TOWN AND COUNTRY PLANNING ACT 1990 NON MATERIAL AMENDMENT

Reference: H07-0638-16 **Date of Decision:** 11th July 2016
Applicant: Mr E Morton-Rowell
19 Station Road
Gedney Hill
Spalding
Lincolnshire
PE12 0NP
Location: Adjacent To 19 Station Road Gedney Hill Spalding Lincolnshire
Description: Proposed 3 bed detached dwelling - approved under H07-0321-16.
Amendment to include 2nd floor in roof space.

SECOND FLOOR PLAN

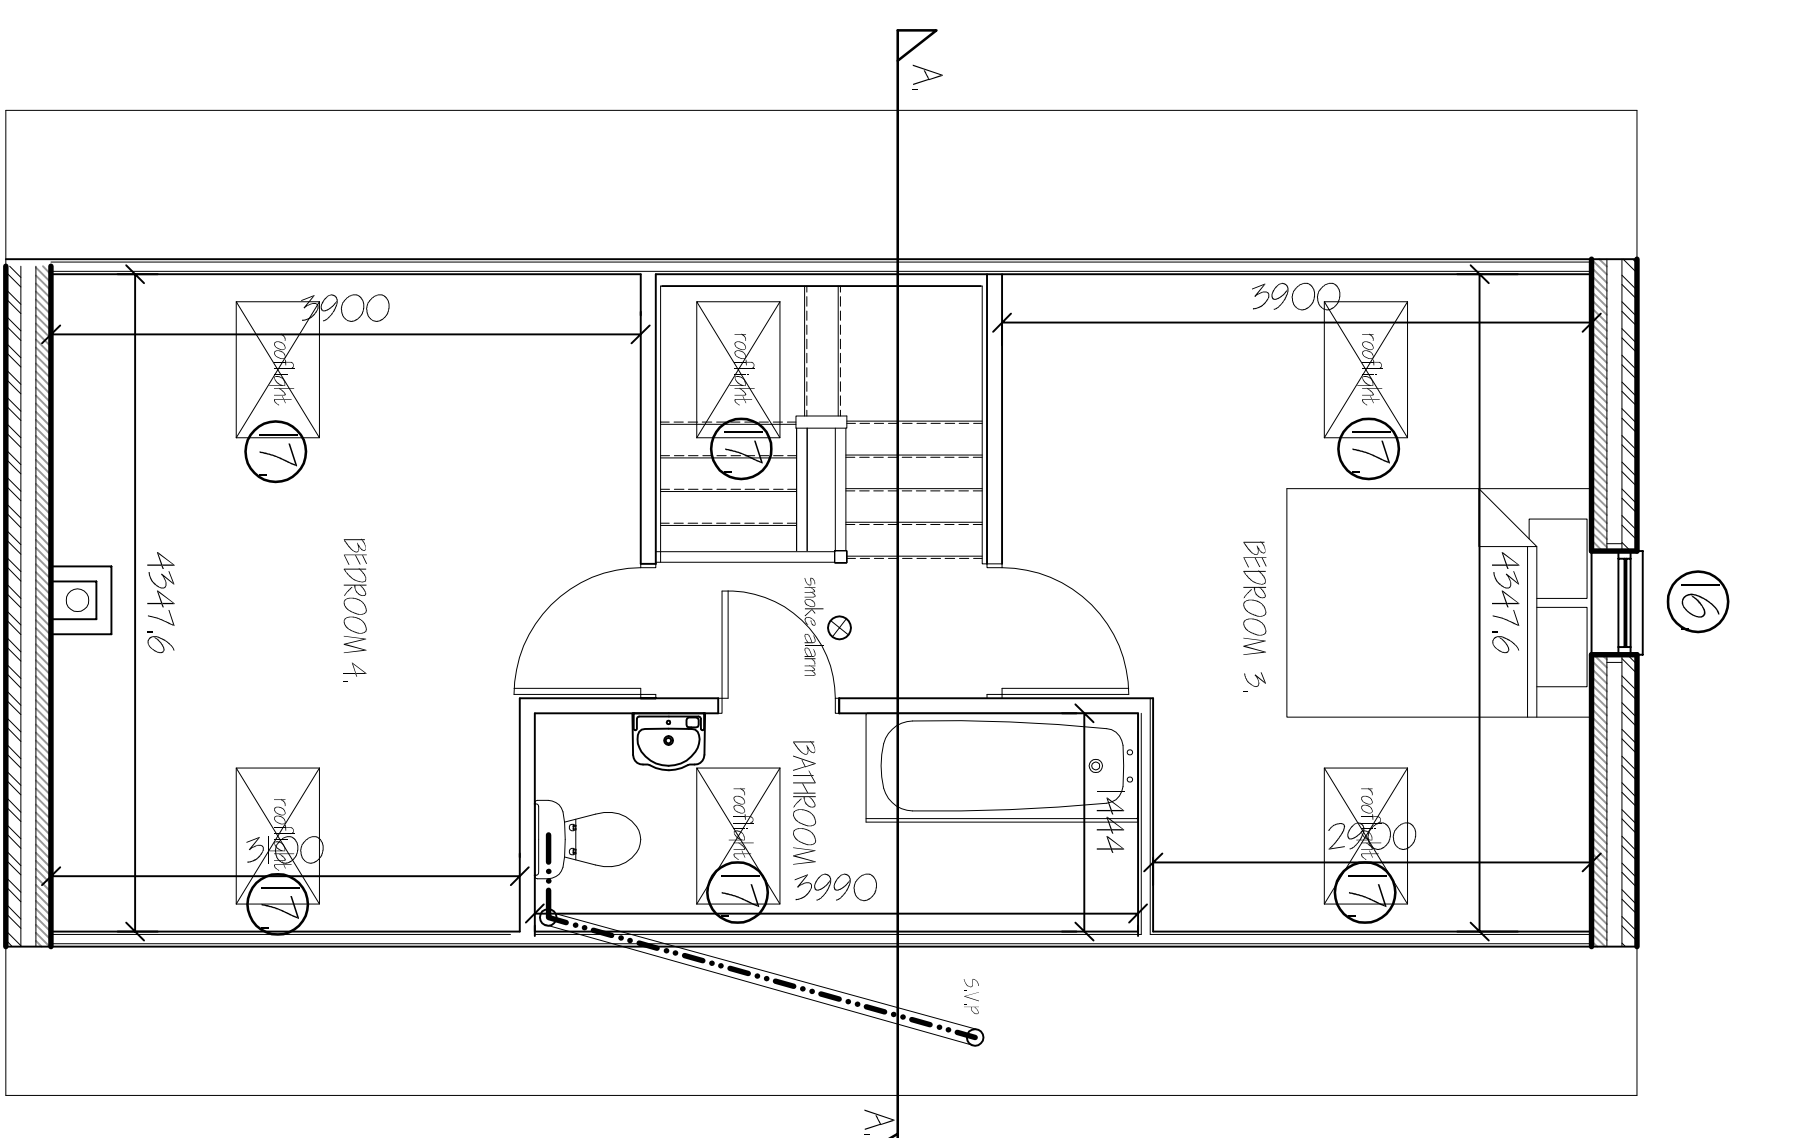
- 1 The proposed amendments do not meet all the criteria of the South Holland District Council's Development Control Procedure Note Non-Material Amendments to Planning Permission, and as such are not considered to represent a Non-Material Amendment. In particular, the proposed revisions include the addition of second floor accommodation and additional windows and as such re-consultations would need to be carried out. These proposed alterations are considered to be a material change and a new application is therefore required to be submitted to vary condition 2 (approved plans) of planning application ref. H07-0321-16.
